Building Inspections - RE: FW: 72 Westminster Ave. - Permit #2014-00179 - ADA handicap accessible ramp

# C9 Structural Notes

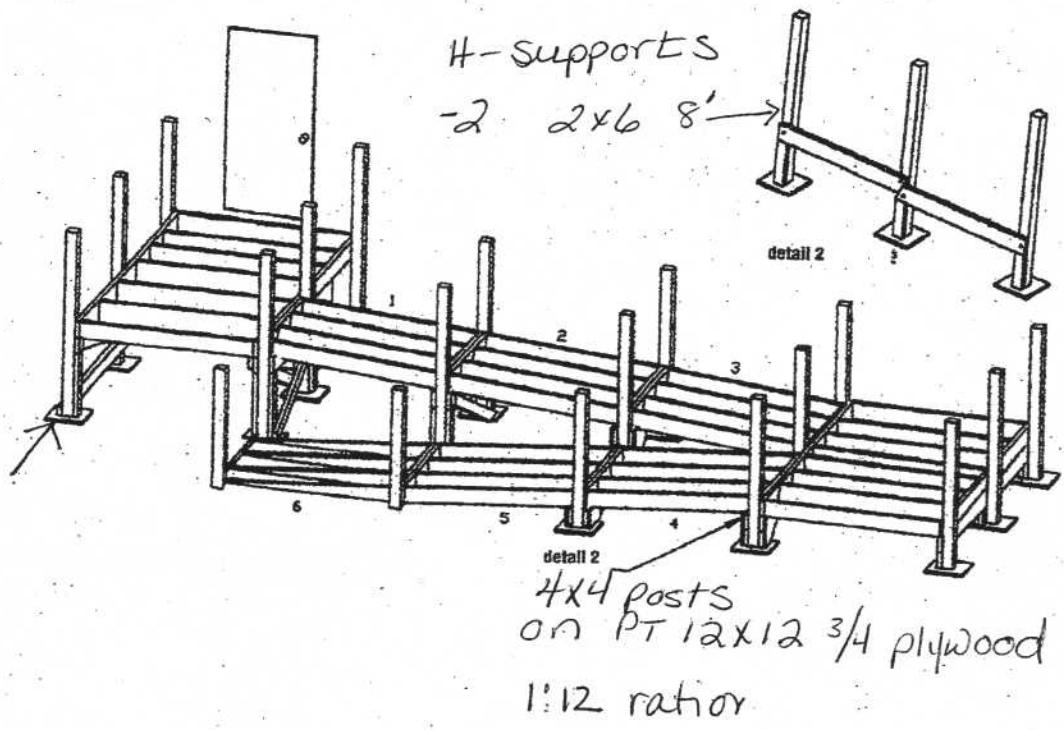
The C1 Structure Plan and the site installation plan show two different setups. I understand that the ramps are 5' in width. The C1 Structure plan shows a 5' x 5' ramp and a 10' x 5' ramp coming off the top landing and a 5' x 10' ramp to a 5' x 5' wedge to the ground from the mid point landing. The site installation plan shows a 10' x 5' ramp coming off the top landing to the mid point landing. Also, how big are the two landings? Sheet C1 shows the large landing as 5' x 8' although the mid point landing would have to be 5' x 10'. I did not see a dimension for the smaller landing at the top.

Per my voice message, the components are all 5' wide and are either 5' or 10' in length. A further breakdown of each component we use is listed on the C1 structural notes submitted with the application.

A-1

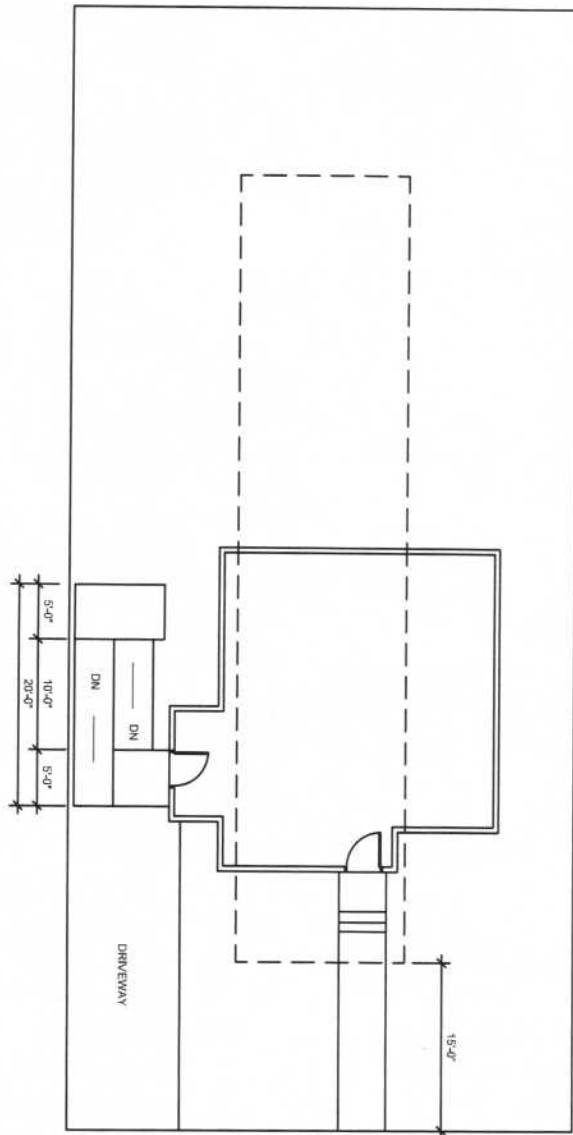
The revised site plan does show the front and rear setbacks. I still need to know what the side setback is going to be. Is it one foot? Half a foot?

The numbers for the ramp and landings still don't make sense. The notes say that the ramps are 5' x 10' yet the landing is only 8' wide and the number at the bottom says the ramp is 3' 6" wide. Are each ramp 10' long by 3' 6" wide and the wedge 5' long by 3' 6" wide?
Please send a revised site plan that shows this.

Second, I need more information on the actual sizes of the landings and ramp sections. The site plan shows the length of the two long ramps as 10' but what are their widths? Also what are the exact sizes of the two landings - one by the door and the one midway?

Third, I need to know what the exact setback is to the side property line and what the setback is to the rear property line for the proposed ramp.

I think I can understand Ann's confusion. I was showing the ramps components as 42 inches wide and the large landing 8 feet wide, based on field measurements of initial CFS installations (see attached images) which would leave only 6" set back as I have added to the plan.
